CITY OF ALBUQUERQUE

Re: TruGreen Chemlawn, 6219 Corona Ave. NE
Grading and Drainage Plan
Engineer's Stamp dated 1-4-06 (C18-D34)

**Re: Trugreen Chemlawn, 6219 Corona Ave. NE, Traffic Circulation
Layout Architect's / Engineer's Stamp dated 01-04-06 (C-18-D34)**

GRADING AND DRAINAGE PLAN  
Sheet Title

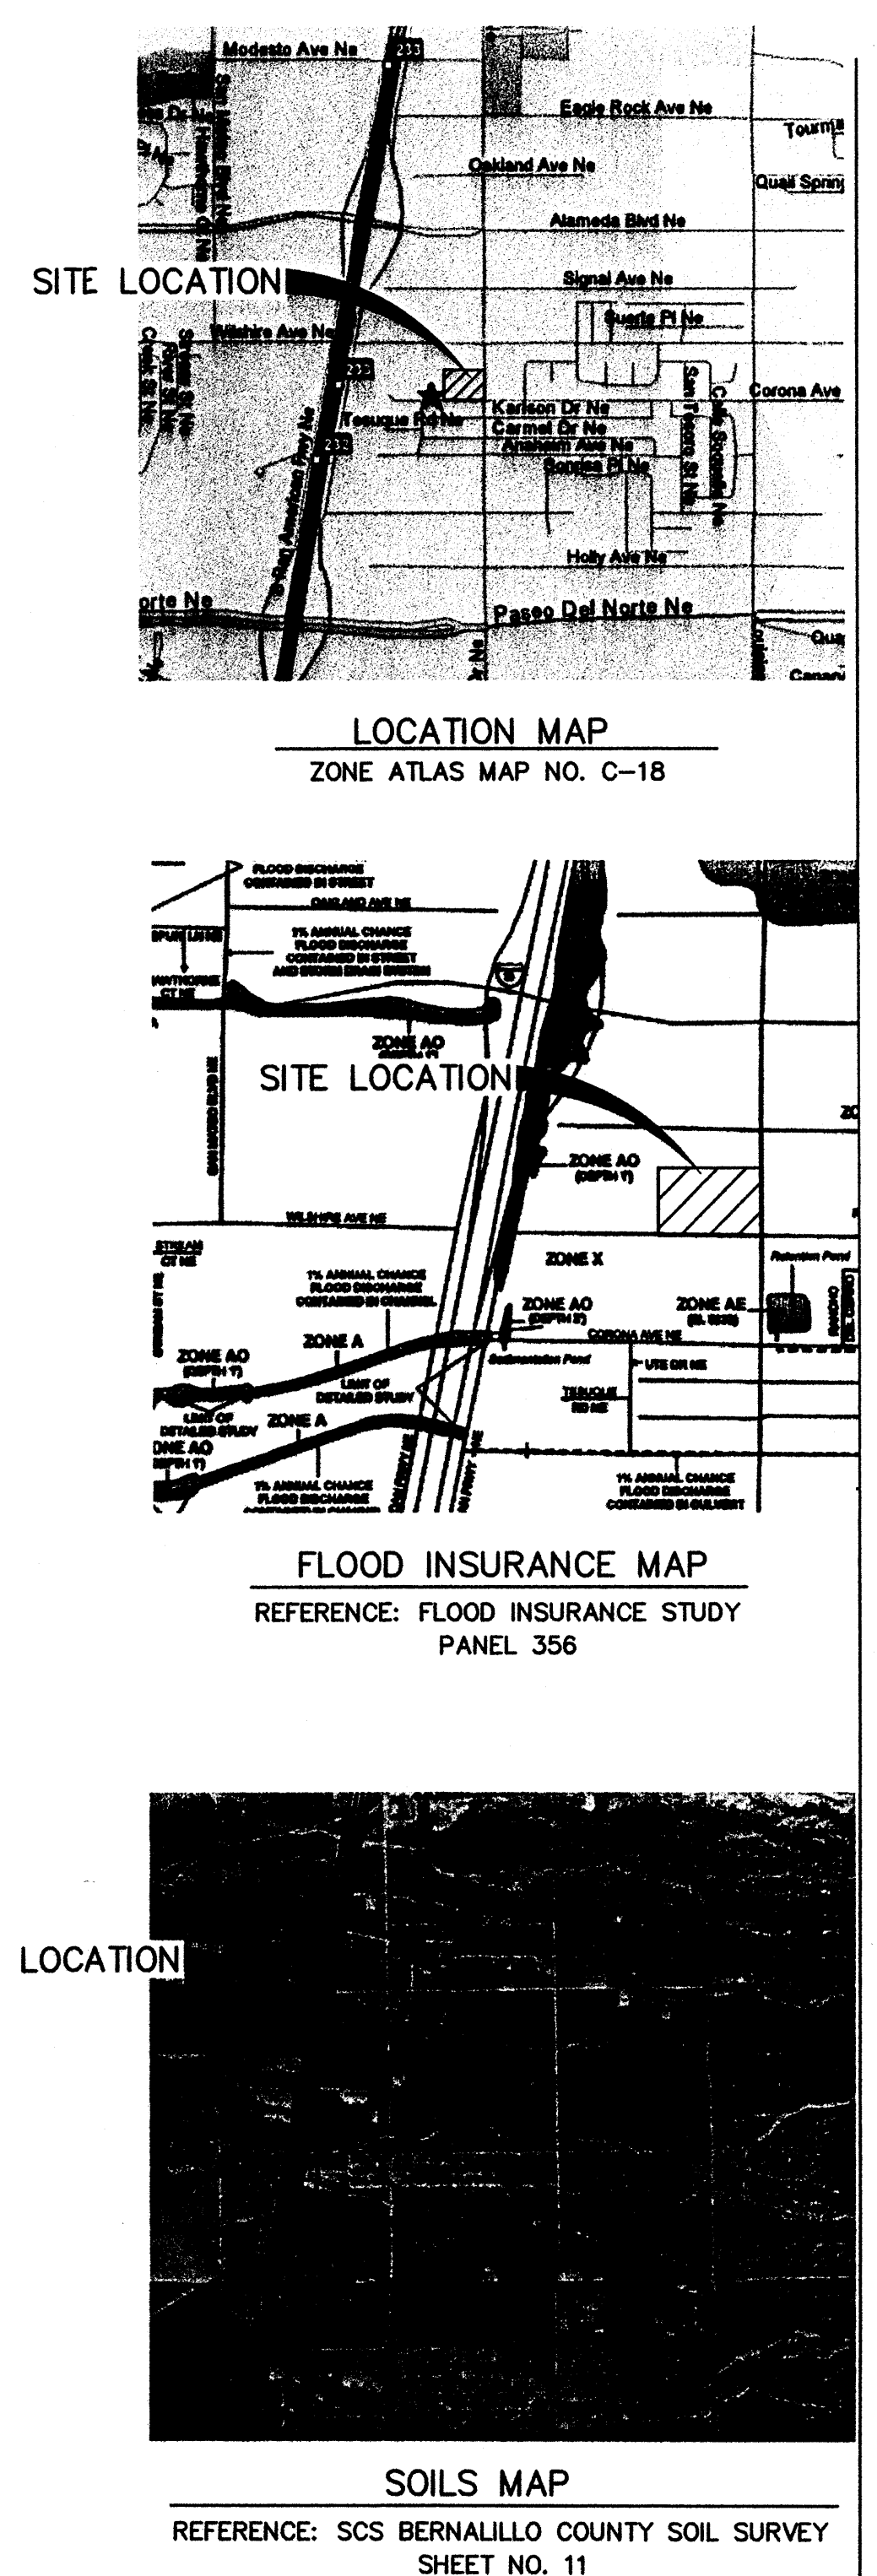
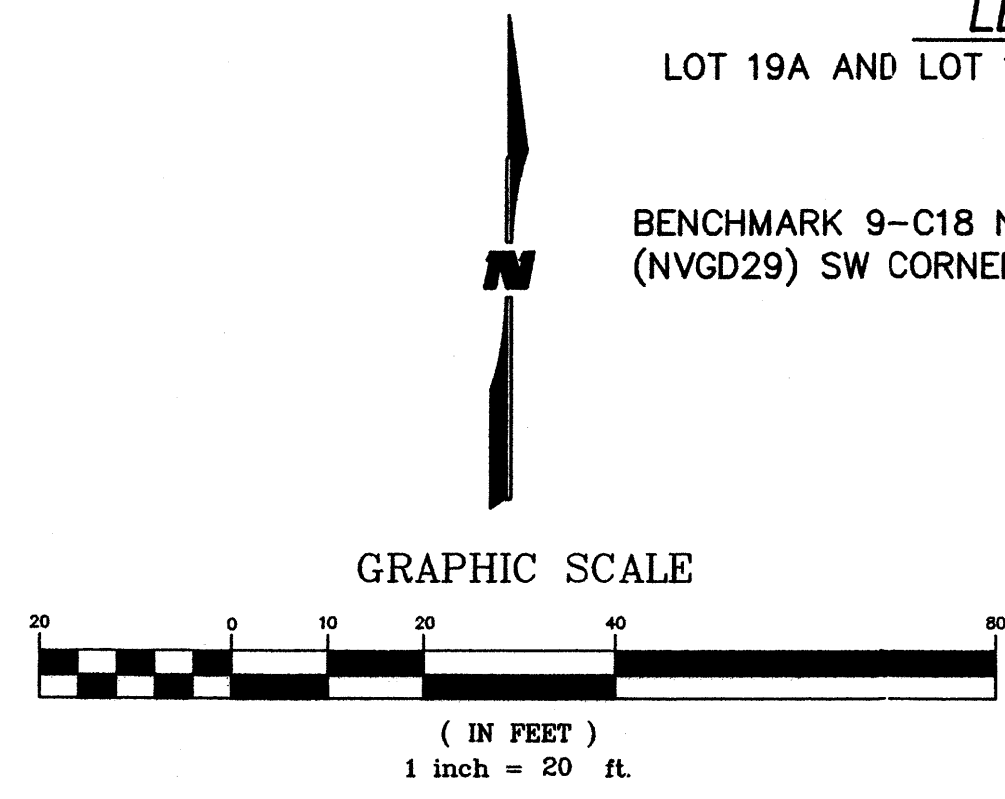
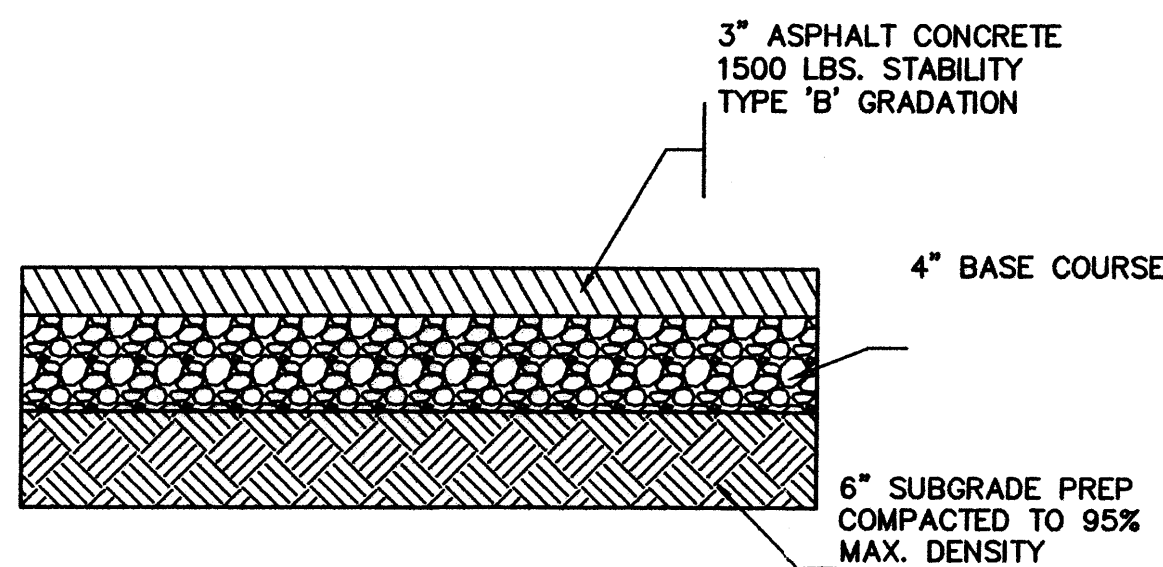
Based upon the information provided in your submittal received 1-04-06, the above referenced plan is approved for Building Permit, Grading Permit and Paving Permit. Please attach a copy of this approved plan to the construction sets prior to sign-off by Hydrology. **Prior to Certificate of Occupancy release, Engineer Certification per the DPM checklist will be required.**
